Comments for Planning Application 24/00225/FULL6

Application Number: 24/00225/FULL6

Address: 30 Manor Park Close West Wickham BR4 0LF

Proposal: Demolition of existing rear extension. Construction of part one/two storey rear/side extension.

Drawing Title **Existing and proposed floor plans and section**

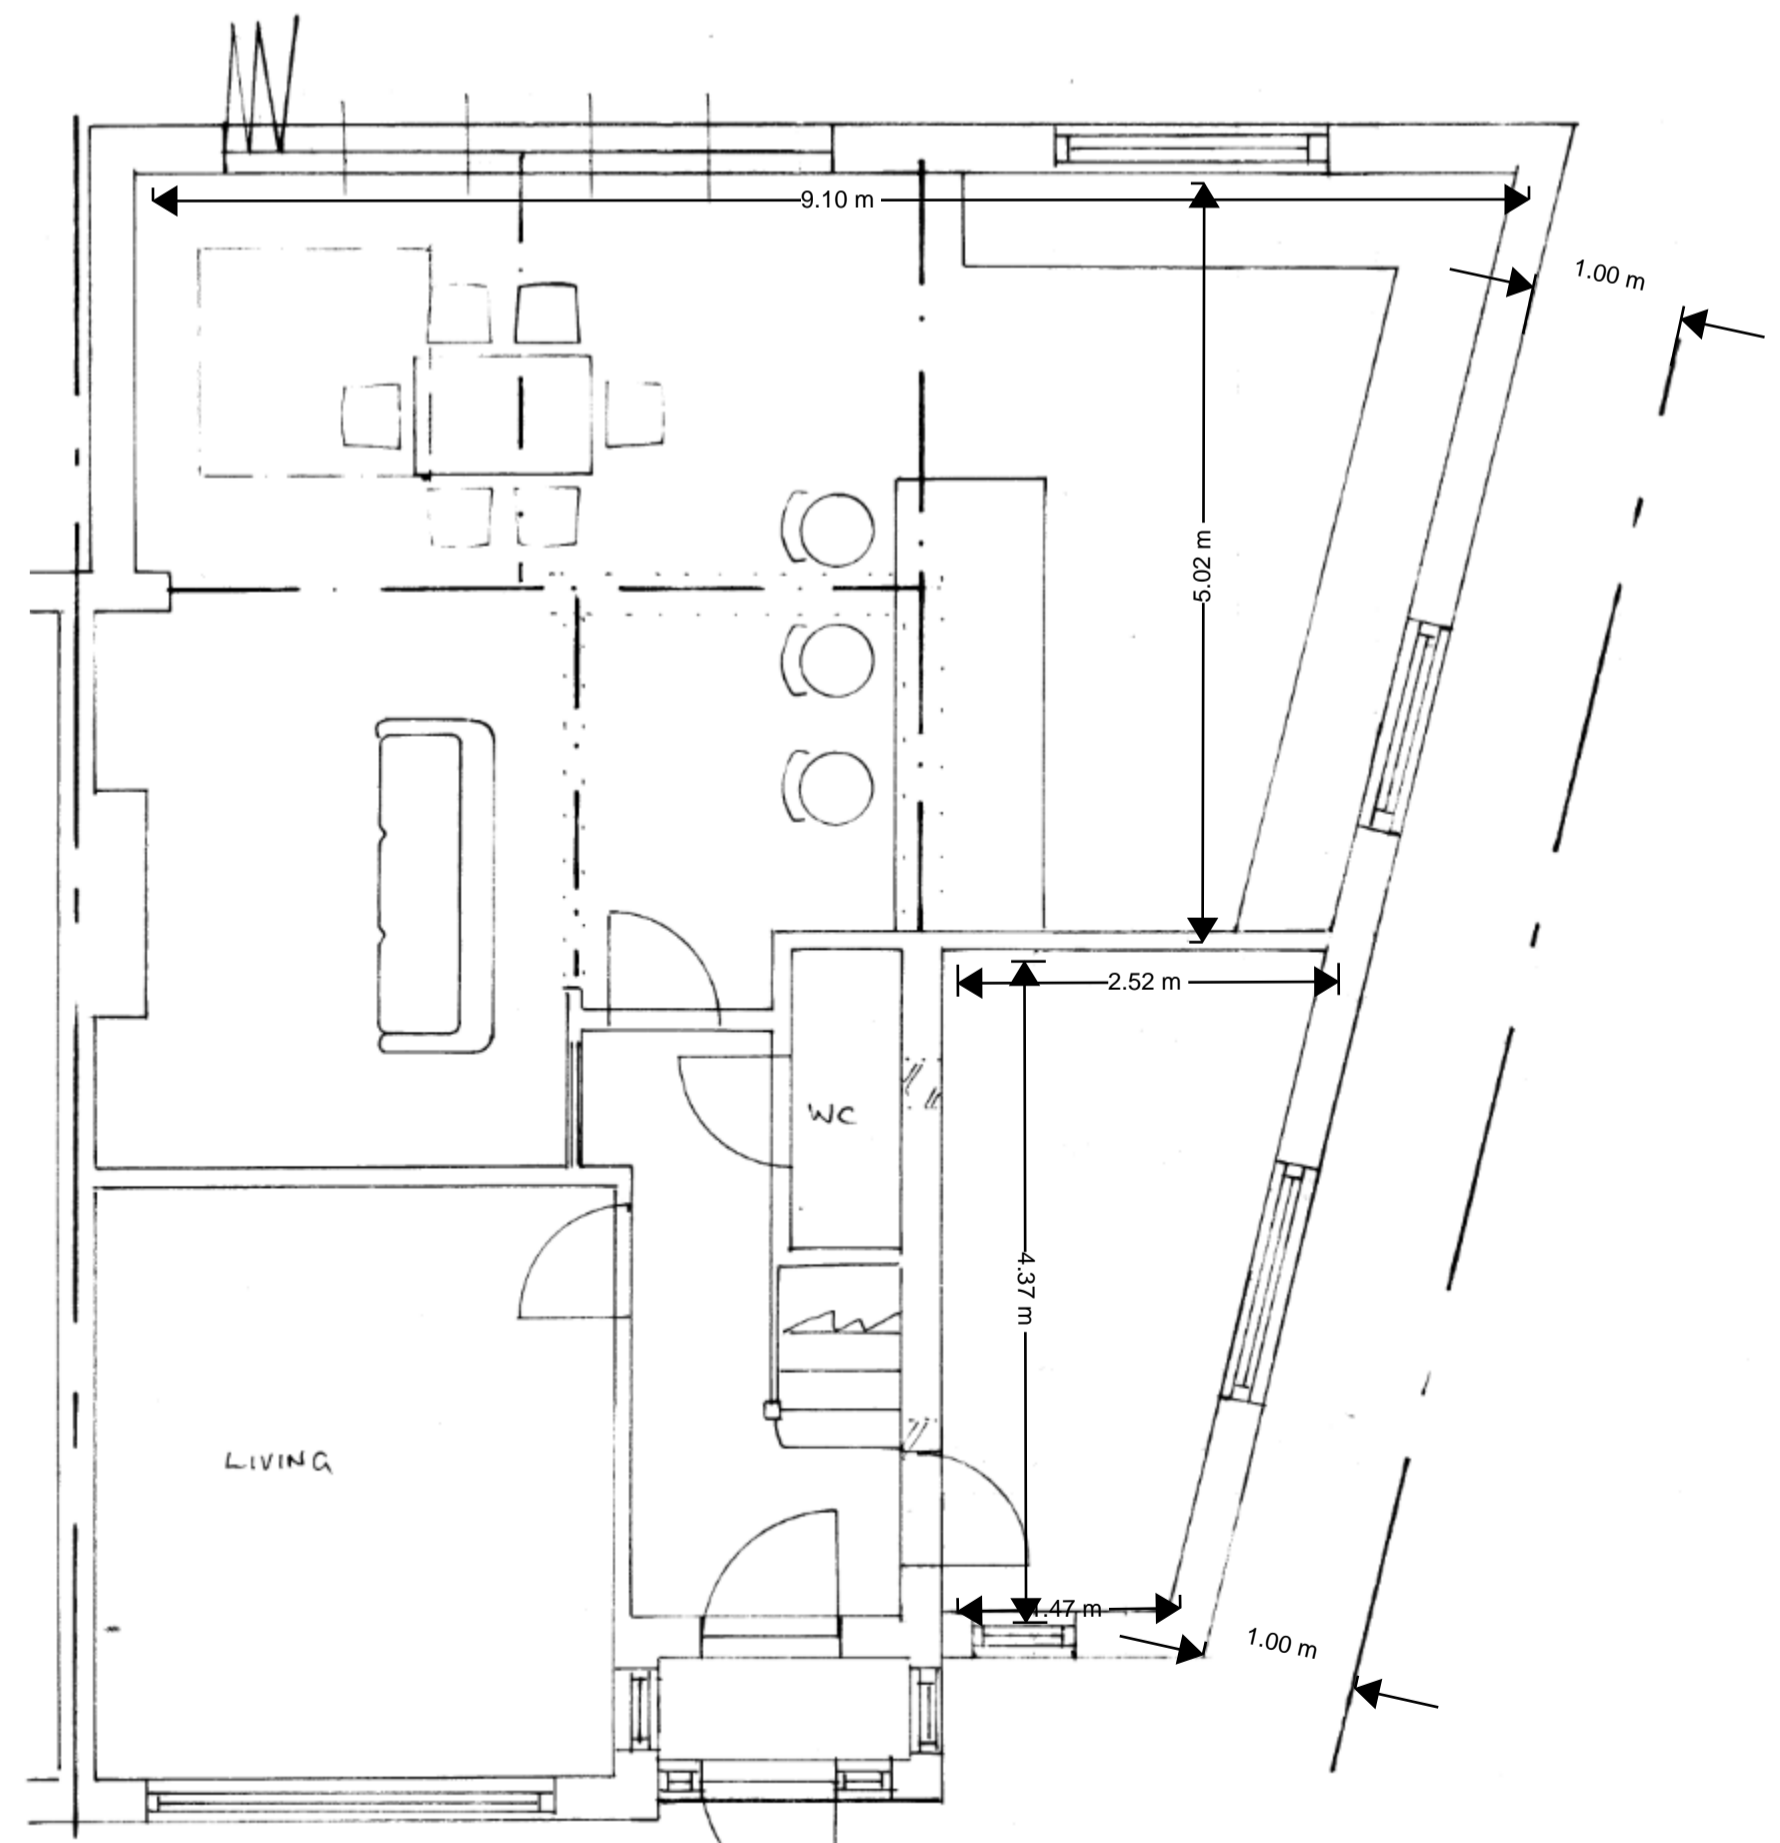
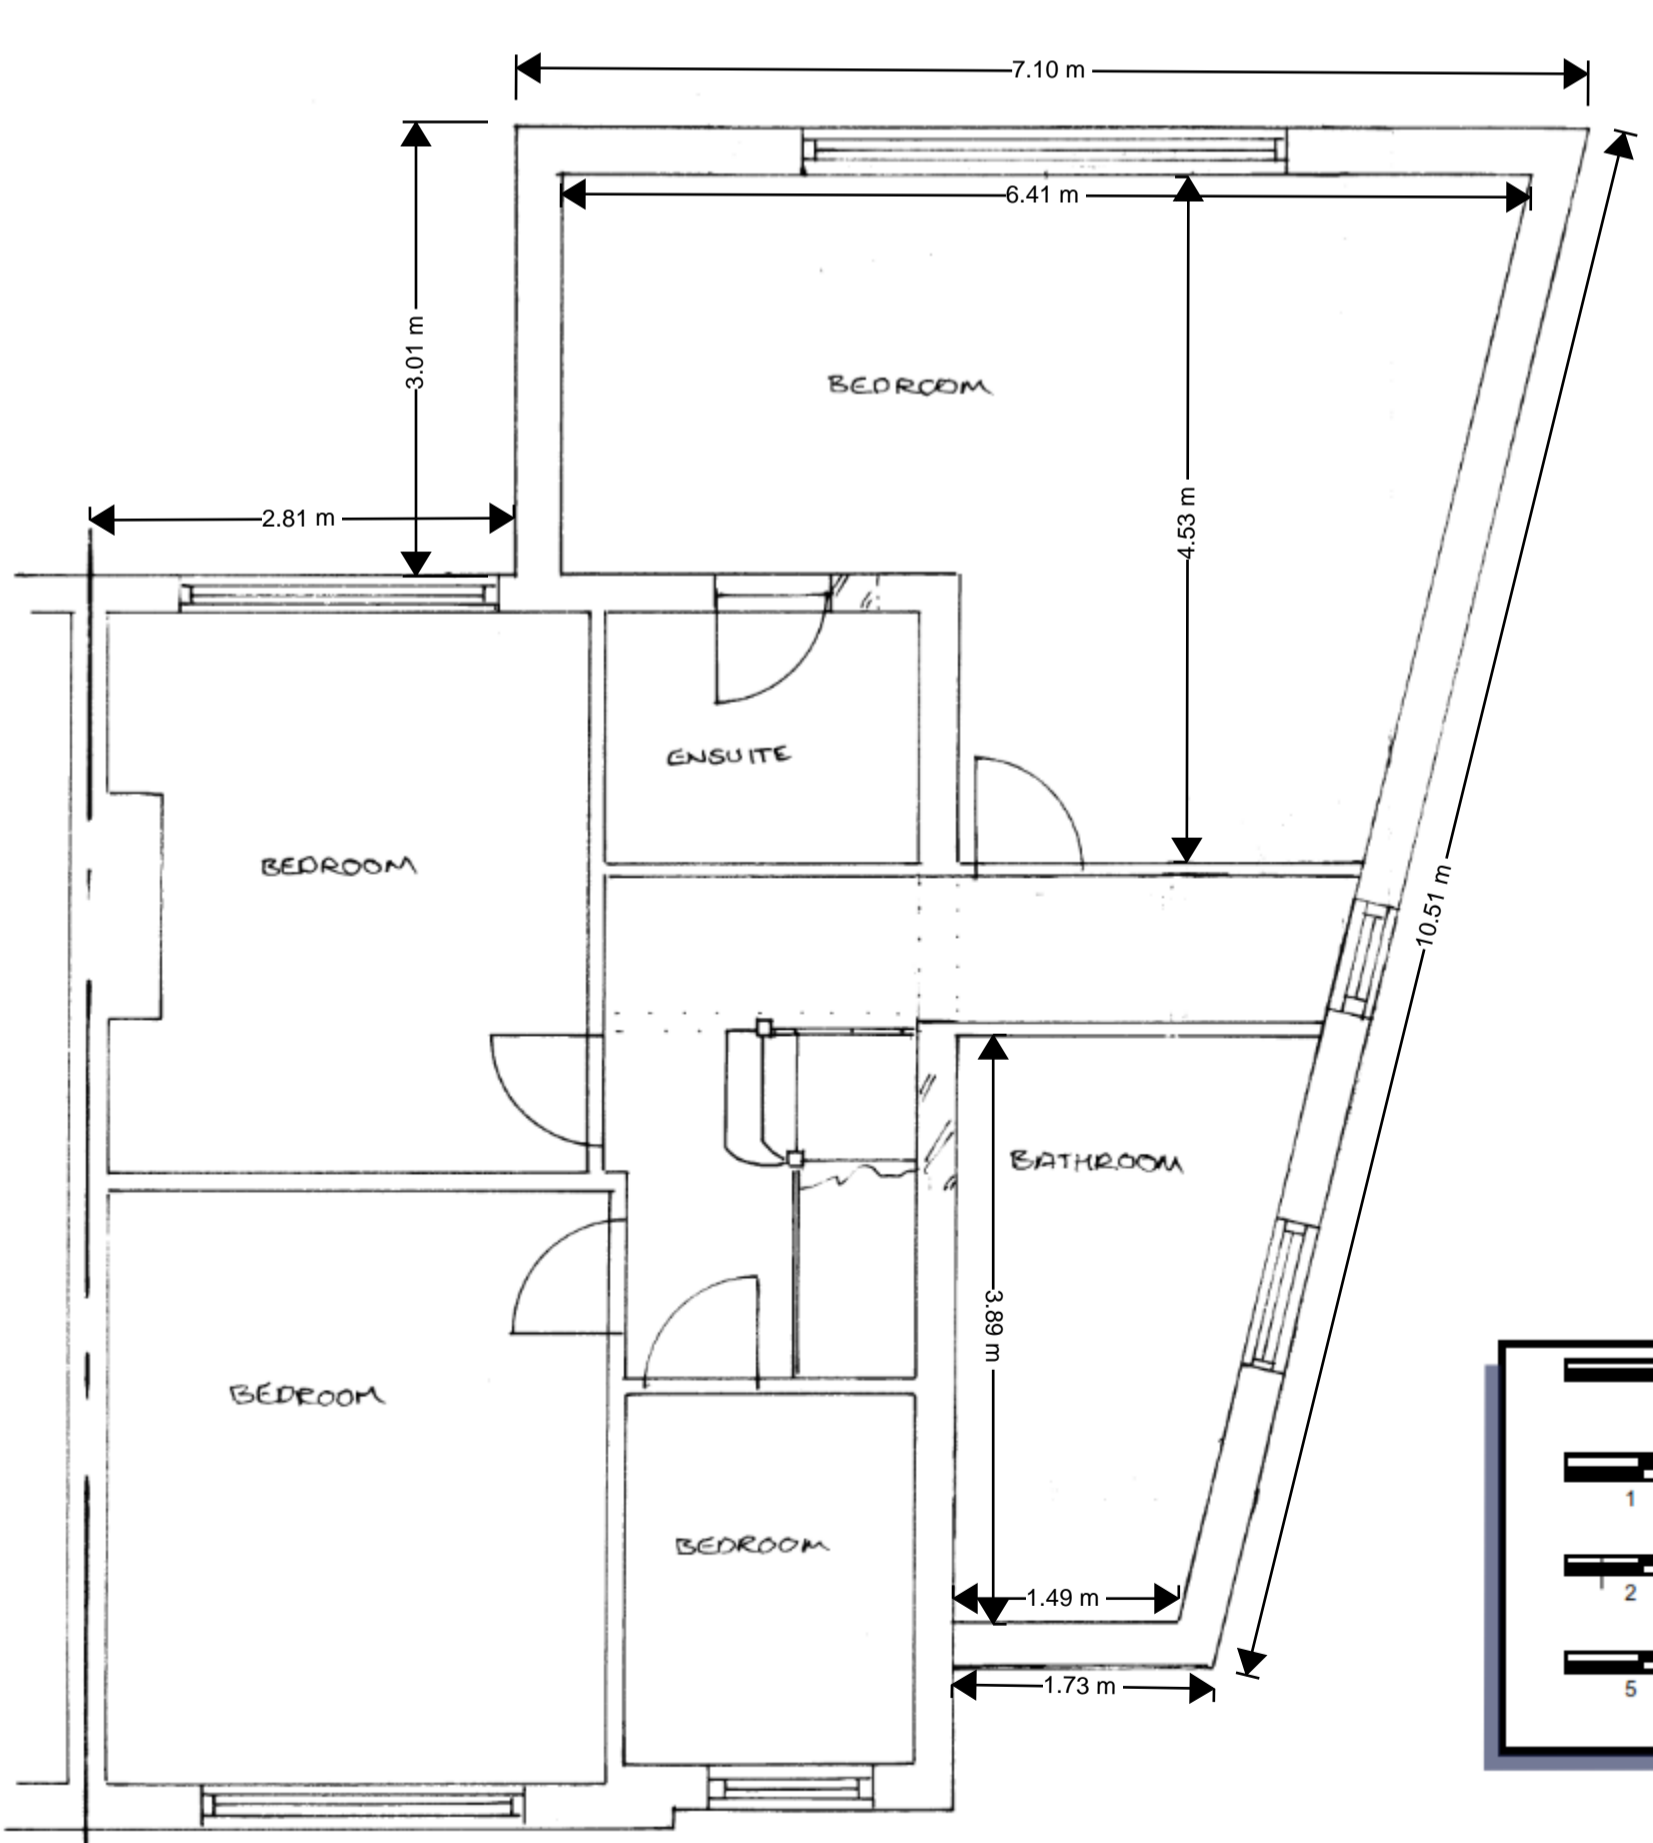
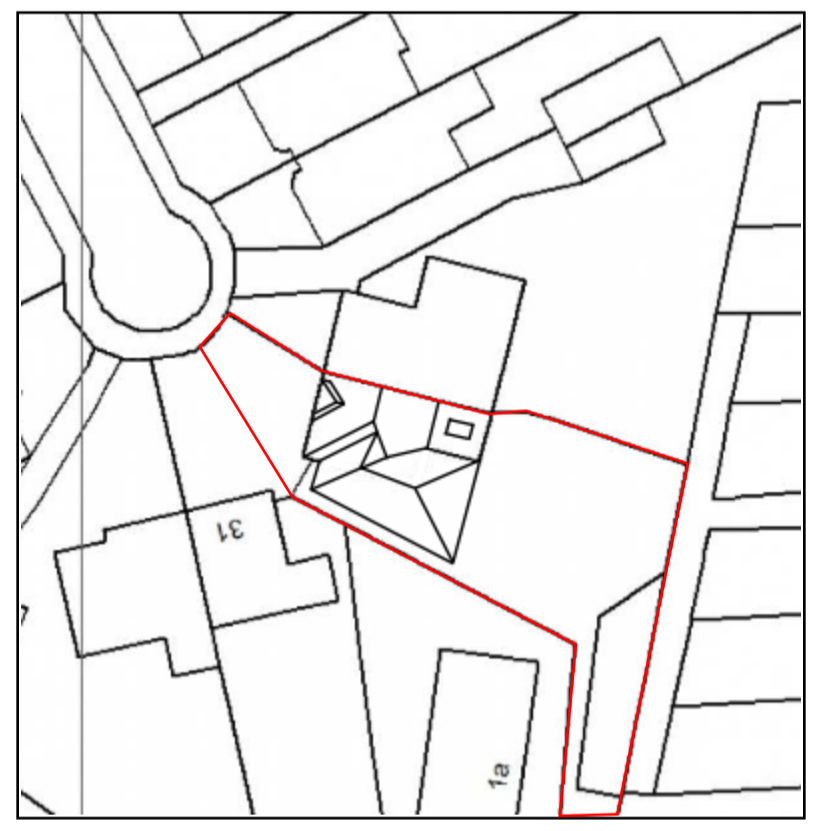
Comment: Please could you clarify the proposed additional extension measurements as difficult to ascertain from the online plans.

Our house backs onto 30 Manor Park Close. We have a small garden and have initial concerns about the proposed close proximity to our property.
